Application by Thurrock Power Ltd for an Order Granting Development Consent for the Thurrock Flexible Generation Plant Project

Response to Procedural Deadline D

Specialist Archaeological Advice

20/00273/DCO Thurrock Flexible Generation Plant, Fort Road, Tilbury

Figure 16

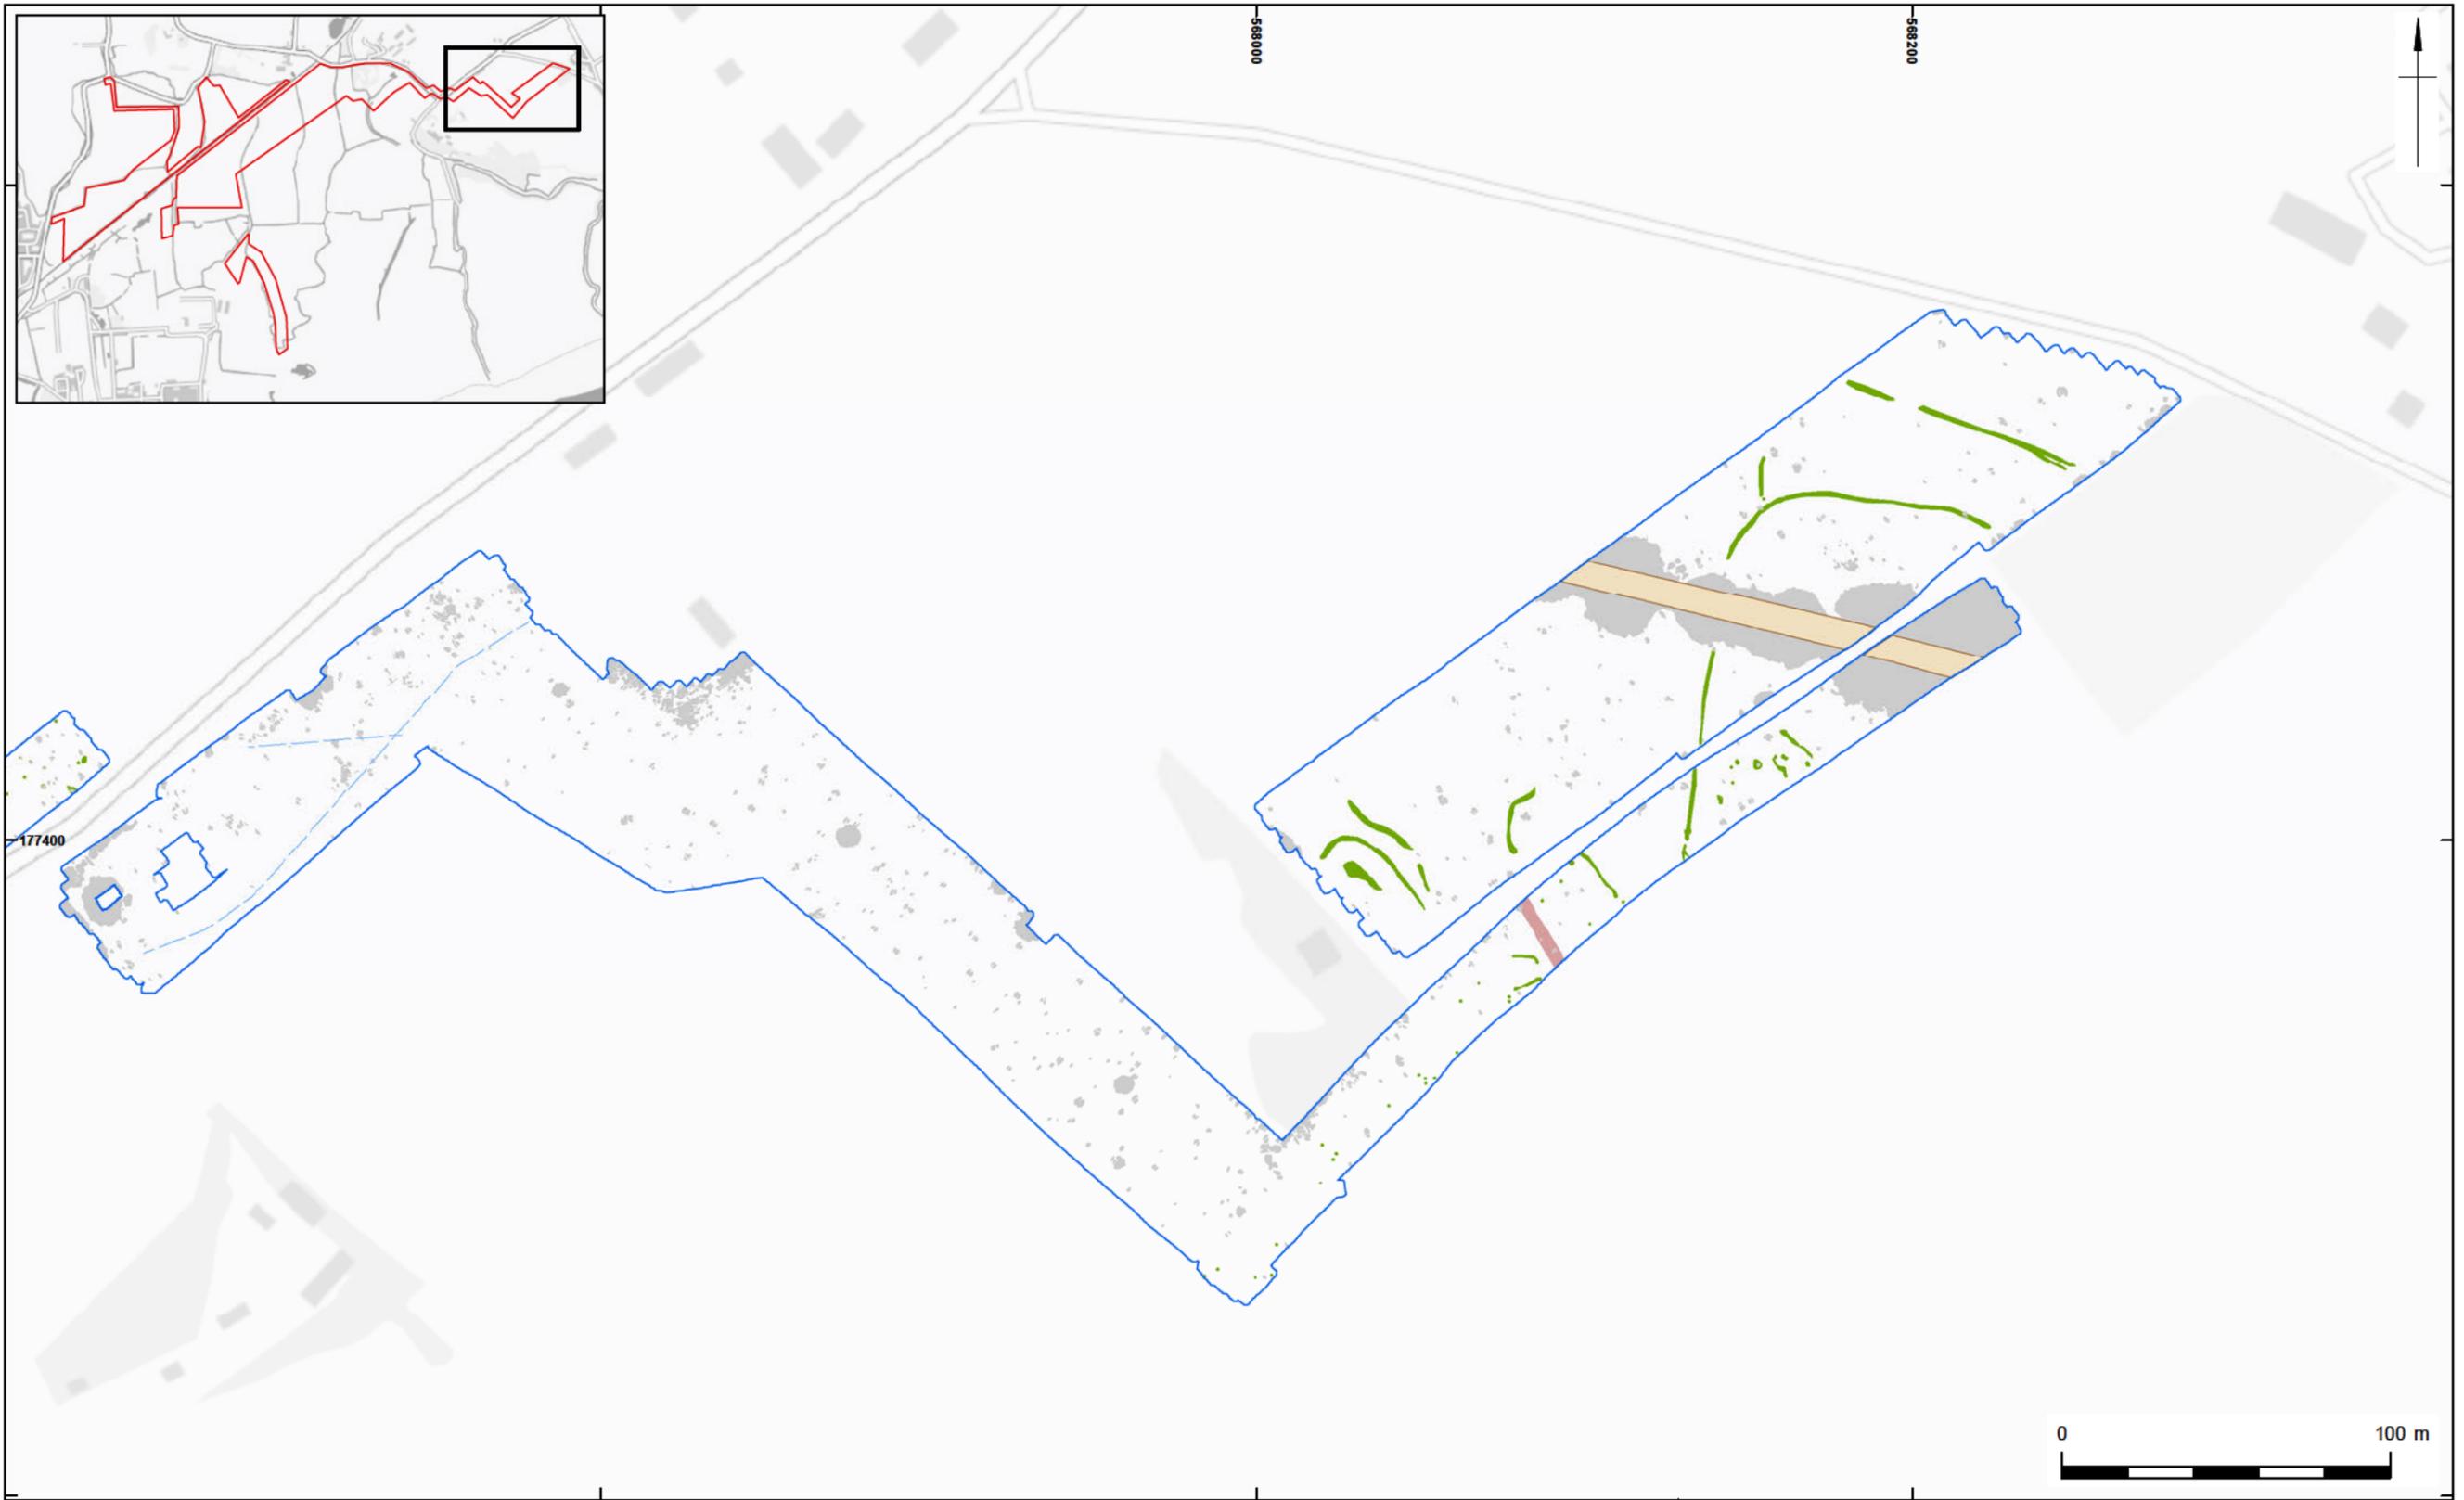
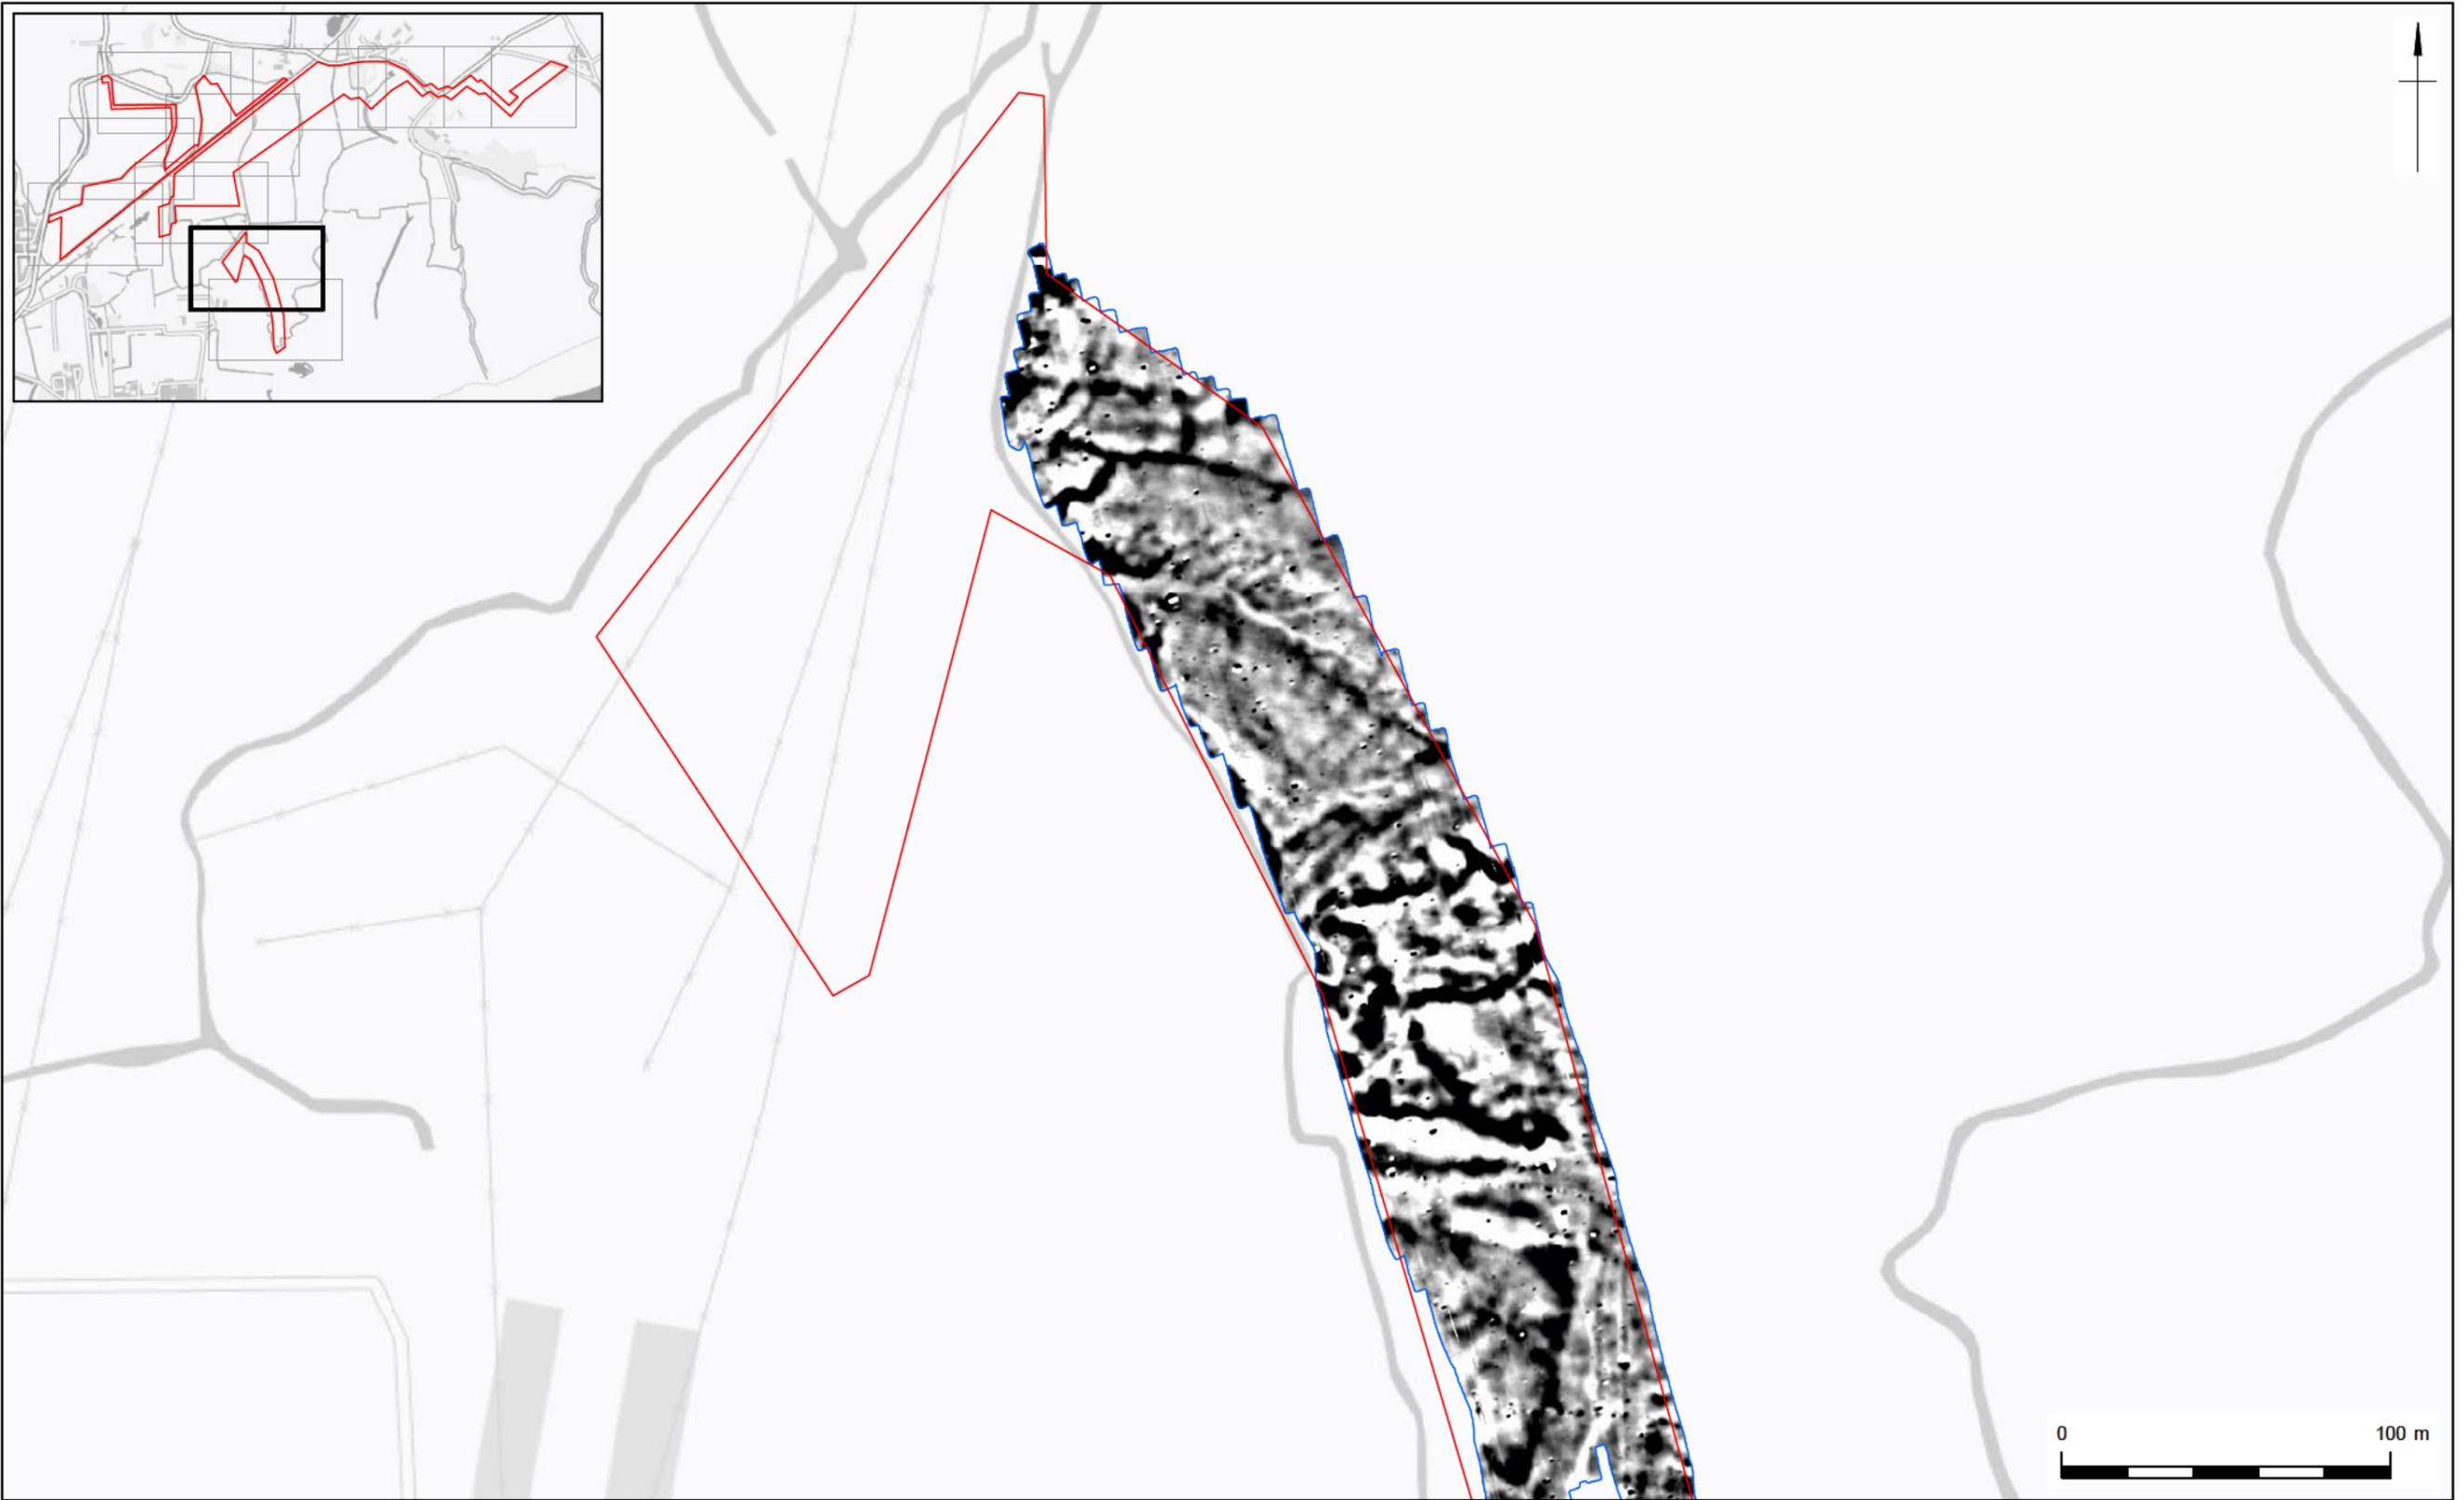
It is pleasing to see that in the documents provided in December that geophysical surveys have been undertaken on the majority of the development area. This provides basic data which can be built on to facilitate an understanding of the historic environment so that the inspector can make an informed decision on the impact of the development. It is disappointing that the applicant does not have the detailed results of the geophysics as the present document provides little detail on the results.

These results also need to be ground truthed to have an understanding as to what the features represent. Large scale developments in the area have shown extensive red hill (saltern) complexes surviving within the grazing marsh area. Similarly, the Lower Thames trial trenching, being undertaken to support their DCO submission has shown an extensive archaeological site of Roman date at the eastern end of this application.
